Response to Submissions (RtS) Comments 12 and 15 November 2021

4 SOUTH EAST ELEVATION - PROPOSED
1 : 500

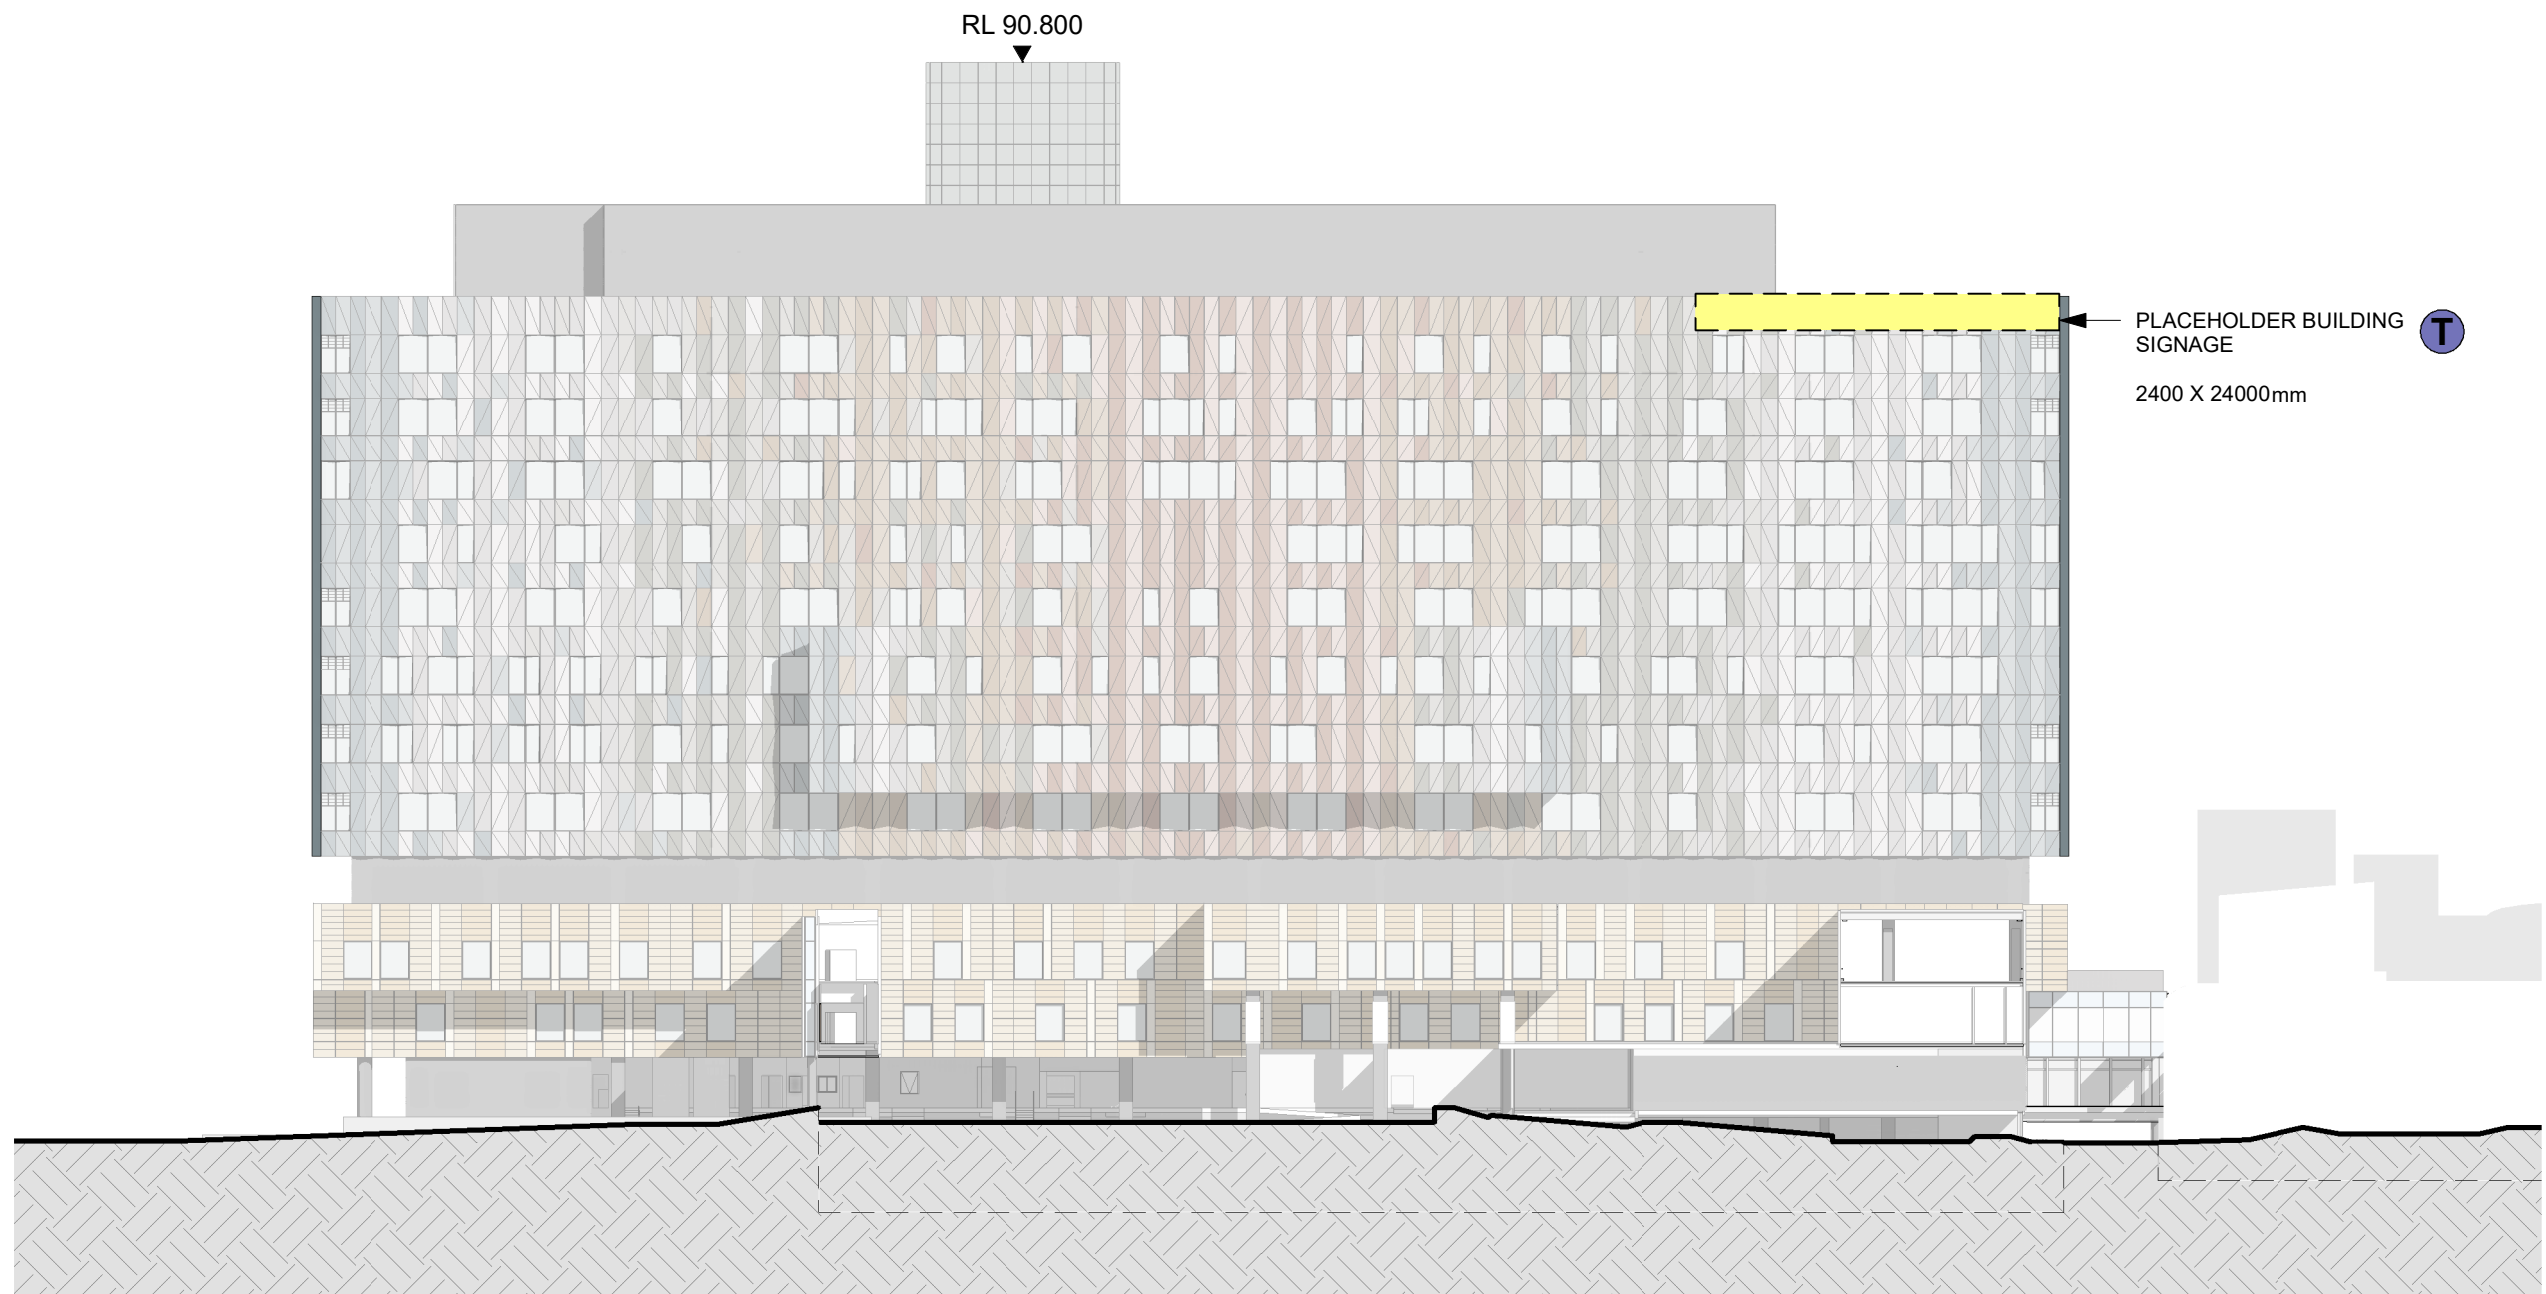
31	<p>provide updated architectural plans showing a consistent building height - the elevations currently detail a maximum building height of RL90.800, while the floor plans and Amendment Report detail a maximum building height of RL90.750.</p>	<p>The architectural documentation has been updated to reflect a consistent RL of 90.800 and removal of the median island including:</p> <p>CHW-AR-DG-PSB-SSD004-01 SITE PLAN - DEMOLITION CHW-AR-DG-PSB-SSD005 SITE PLAN - PROPOSED CHW-AR-DG-PSB-SSD011 PROPOSED PLAN - LEVEL 02 CHW-AR-DG-PSB-SSD012 PROPOSED PLAN - LEVEL 03 CHW-AR-DG-PSB-SSD013 PROPOSED PLAN - LEVEL 04 CHW-AR-DG-PSB-SSD014 PROPOSED PLAN - LEVEL 05 CHW-AR-DG-PSB-SSD015 PROPOSED PLAN - LEVEL 06 CHW-AR-DG-PSB-SSD016 PROPOSED PLAN - LEVEL 07 CHW-AR-DG-PSB-SSD017 PROPOSED PLAN - LEVEL 08 CHW-AR-DG-PSB-SSD018 PROPOSED PLAN - LEVEL 09 CHW-AR-DG-PSB-SSD019 PROPOSED PLAN - LEVEL 10 CHW-AR-DG-PSB-SSD020 PROPOSED PLAN - LEVEL 11 CHW-AR-DG-PSB-SSD021 PROPOSED PLAN - LEVEL 12 CHW-AR-DG-PSB-SSD022 PROPOSED PLAN - LEVEL 13 CHW-AR-DG-PSB-SSD023 PROPOSED PLAN - LEVEL 14 CHW-AR-DG-PSB-SSD024 PROPOSED PLAN - LEVEL 15 CHW-AR-DG-PSB-SSD025 PROPOSED PLAN - LEVEL 16 CHW-AR-DG-PSB-SSD027 PLAN - FORECOURT RETAIL & CANOPY CHW-AR-DG-PSB-SSD028 ROOF PLAN - FORECOURT RETAIL & CANOPY CHW-AR-DG-PSB-SSD040- SITE PLAN - SOLAR STUDY - SHEET 01 CHW-AR-DG-PSB-SSD041 - SITE PLAN - SOLAR STUDY - SHEET 02 CHW-AR-DG-PSB-SSD055 GFA CALCULATIONS SHEET 1 CHW-AR-DG-PSB-SSD060 VIEW ANALYSIS - PHOTO MONTAGE - RENDERS - SHEET 01</p>
